Subject: AW/198/18/PL

The proposed dwelling is located within the Craigweil House Conservation Area.

DRAWING TITLE
Site Plan, Block Plan and Location Plan

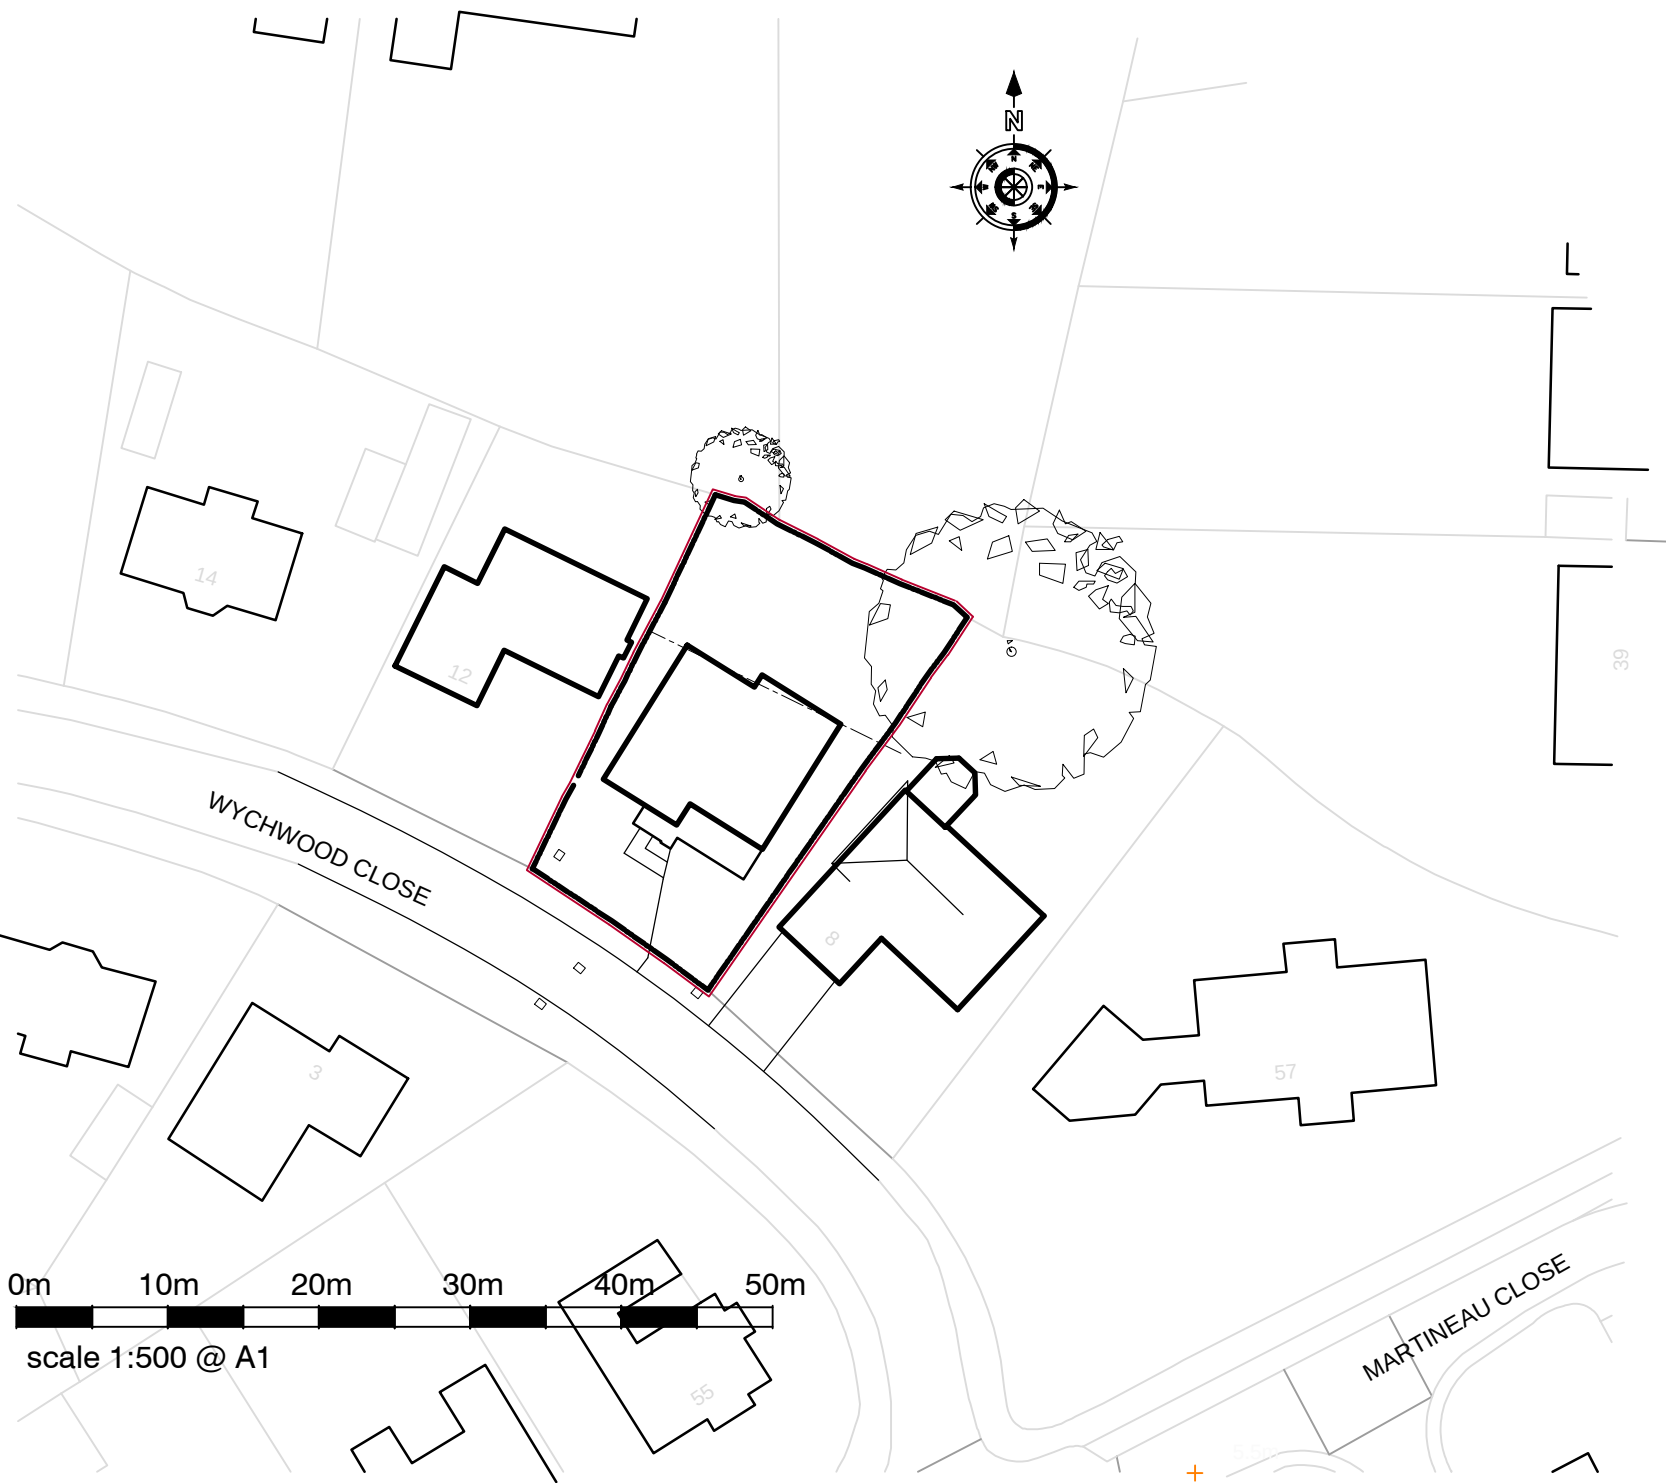
The application also includes a cross over from the highway to the site, and details regarding the paving materials to be used should be provided.

The hard surfacing will be formed with Marshalls Drivesett Light Argent Priora Permeable Block Paving

DRAWING TITLE
Proposed Plans and Elevations

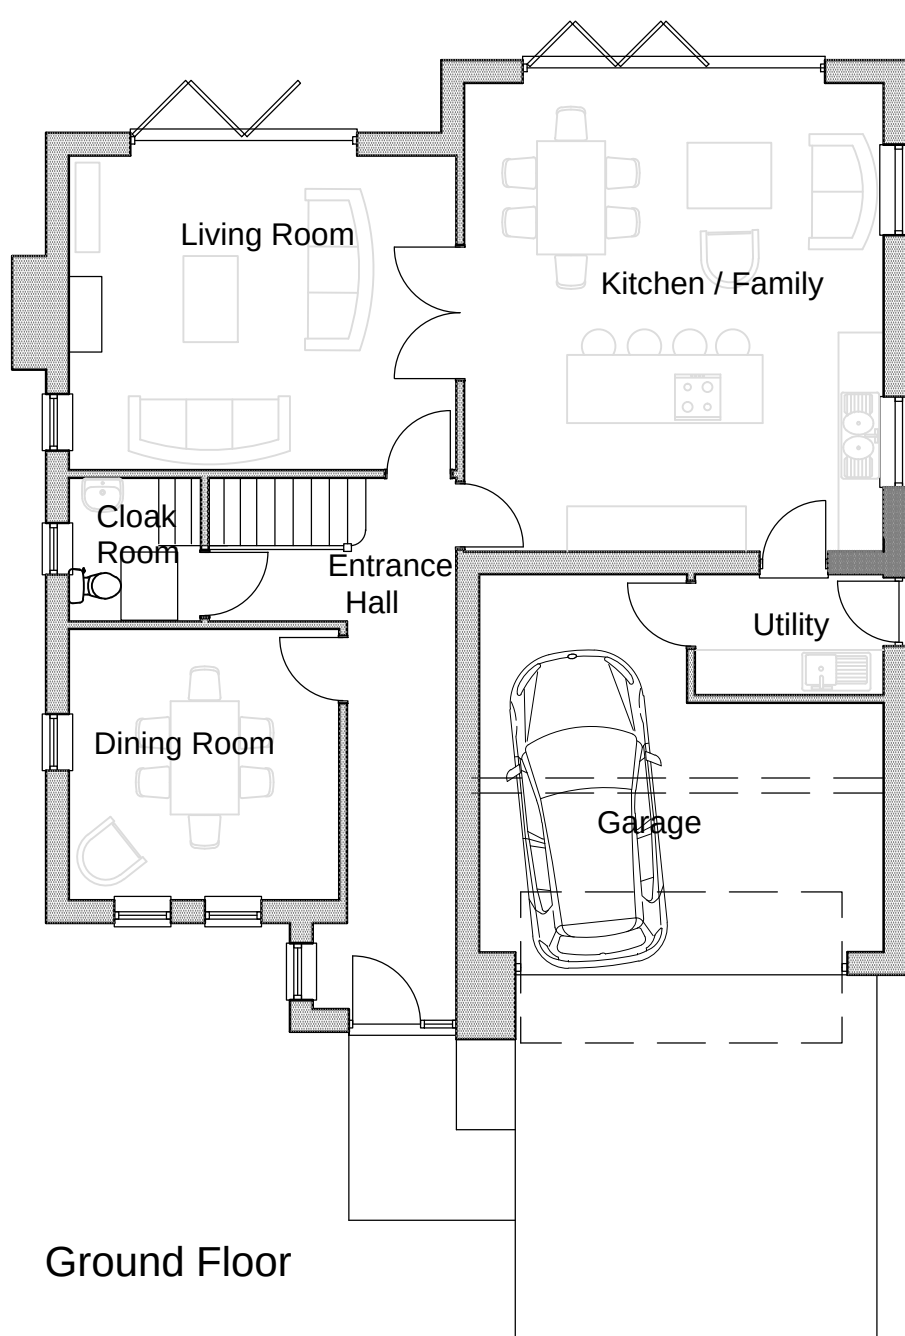
I do have some concerns regarding the use of Cedar boarding, but this may be acceptable depending on the colour/appearance proposed. Maybe this can be confirmed?

Roof – Wienerberger Calderdale Edge in Dark Grey
Fascia – uPVC – white
Rainwater goods – galvanised steel
Walls – through coloured render in white
Wall adjacent to entrance – split faced stacked slate (slate colour)
Windows and doors – uPVC anthracite RAL 7016

The boarding will be Marley Cedral Click, in light grey.
